STRATFORD EXTENSION PROJECT: SSD-4966

ENVIRONMENTAL IMPACT STATEMENT

SUBMISSION BY THE BARRINGTON-GLOUCESTER-STROUD PRESERVATION ALLIANCE

January 2013

Figure 1a: Land ownership for Stratford Extension Project and surrounds

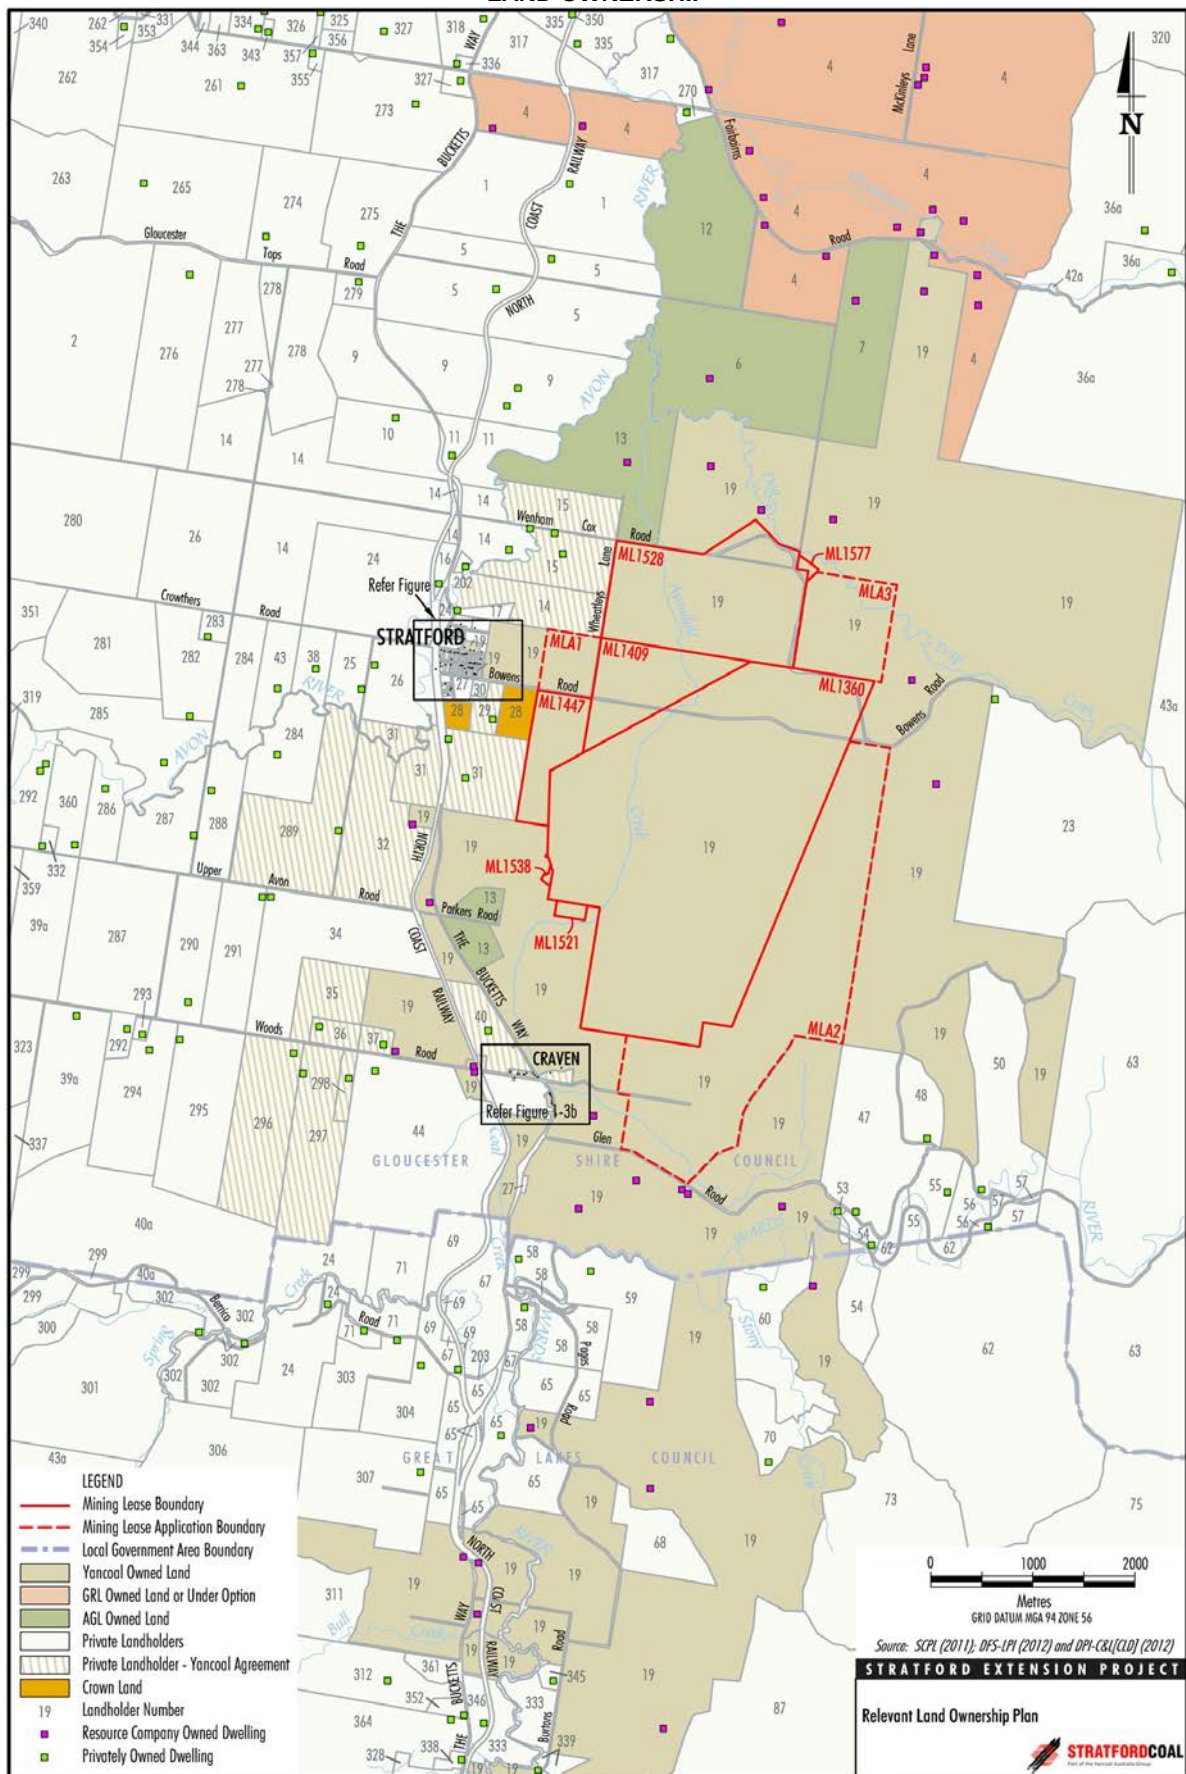
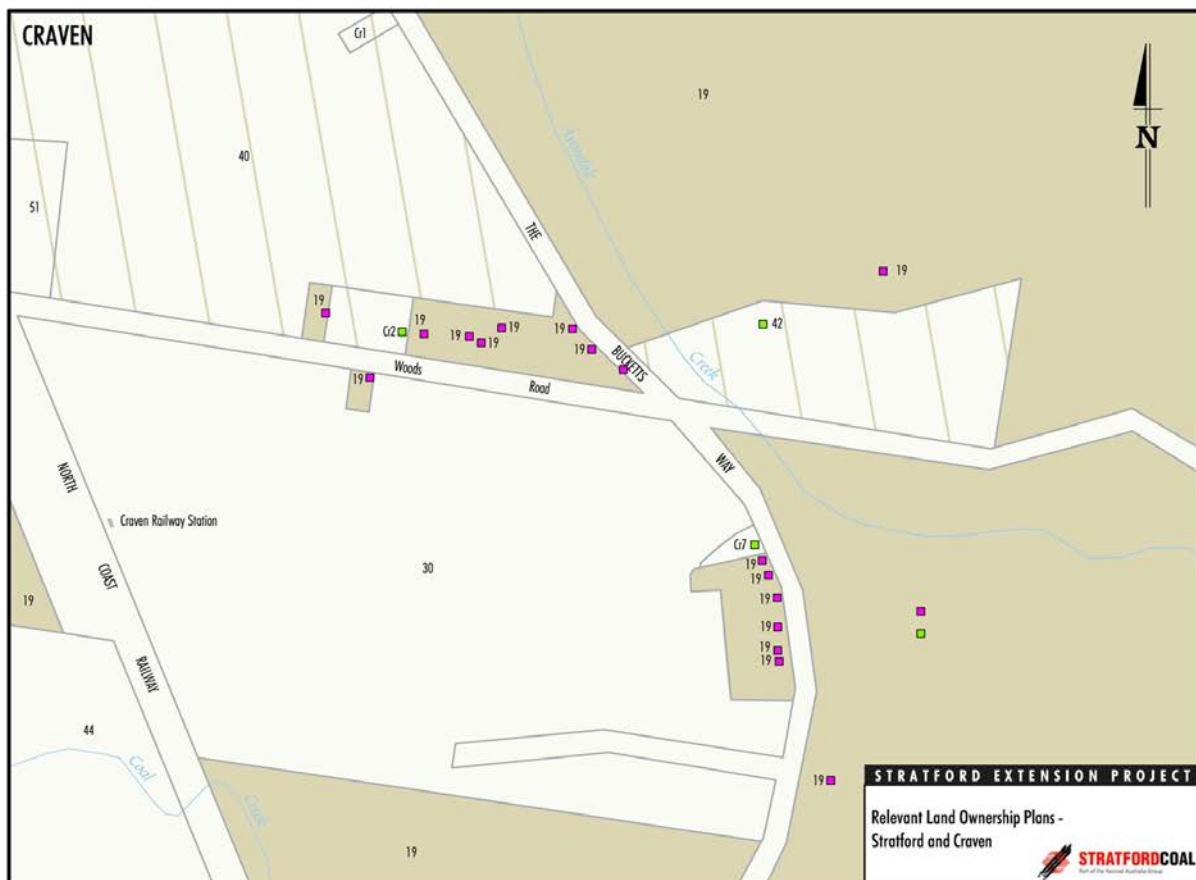
If the owners of the properties identified in the Relevant Land Ownership Plan in the EIS (Figures 1-3a, 1-3b and 1-3c) seek to sell their property for any reason during the course of this project and the property is unable to be sold because of the proximity of the Stratford mining complex, SCPL must acquire the property in accordance with the procedures in condition 11.1 of the BRNOC development consent (DA-39-02).
